CORDERO REZONE

**Subject: Cordero Minor Subdivision – Final Plat**  
**File Number MS-17-001; El Paso County, CO; CGS Unique No. EP-17-0028**

Subject: Cordero Minor Subdivision – Final Plat – (MS-17-001)

**Cordero Minor Subdivision  
(MS-17-1)**

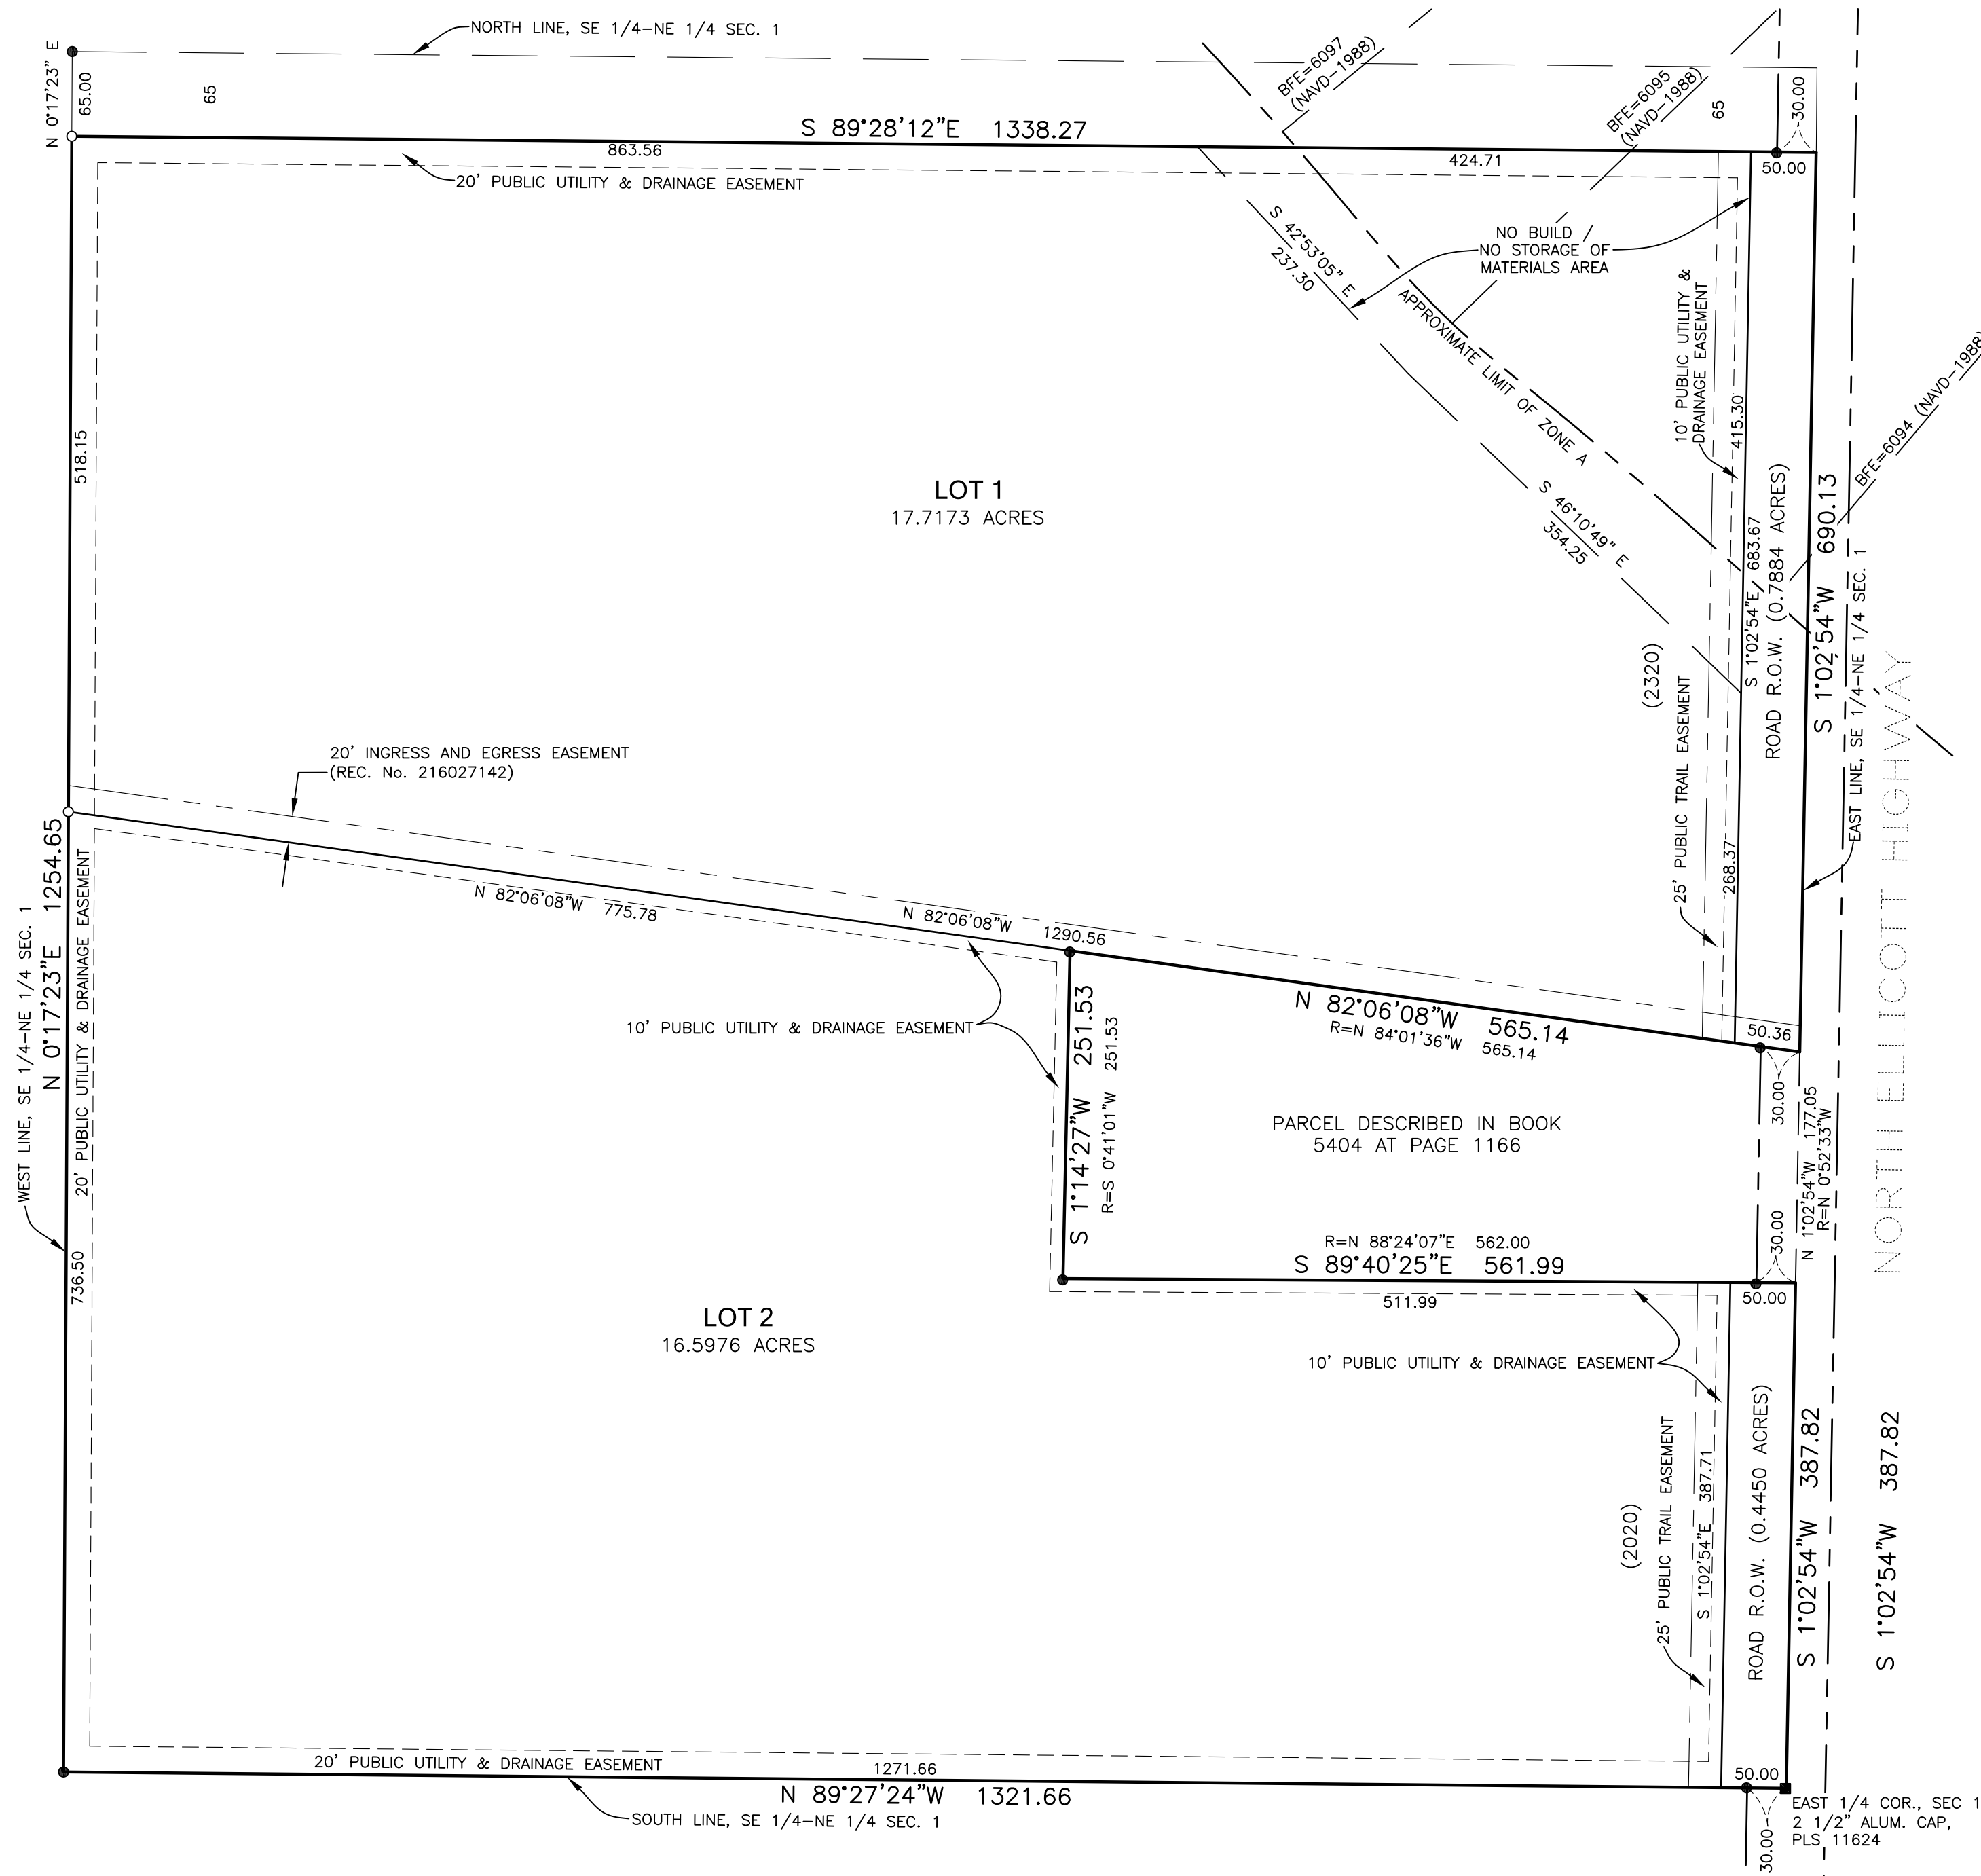
**Setback from drainage.** An intermittent drainage and a sand wash traverse the eastern portion of proposed Lot 1, east of the existing Lot 1 building location. No flood hazard zone has been designated for this drainage. Future improvements on proposed Lot 1 should be set back as far as possible from the drainage to minimize risks associated not just with flooding but also erosion and deposition.

The proposed plat doesn't show an existing or proposed easement for Bunny View. It appears as though this is the only access to the 8 mobile homes north of this site. Please confirm there is an easement in this location, or provide one.

**Response:** Bunny View as a private road is no longer in existence; it has been replaced with an easement filed with the Clerk and Recorder, El Paso County, Colorado, on 17 March 2016 at Reception No. 216027142. I have included a copy of the Ingress Egress Easement Agreement along with the corresponding exhibits. Additionally, access to and from the mobile home park is via the new Ingress Egress Easement Agreement and a North to South access road which was created by the owners of the mobile home park. Betina Tacoronte f/k/a Betina S. Parker and Cleveland Tadiarca, with an address of 2202 Ellicott Highway N., Calhan, CO 80808 are also the owners of the mobile home park. I have included a PowerPoint slide depicting the above references.
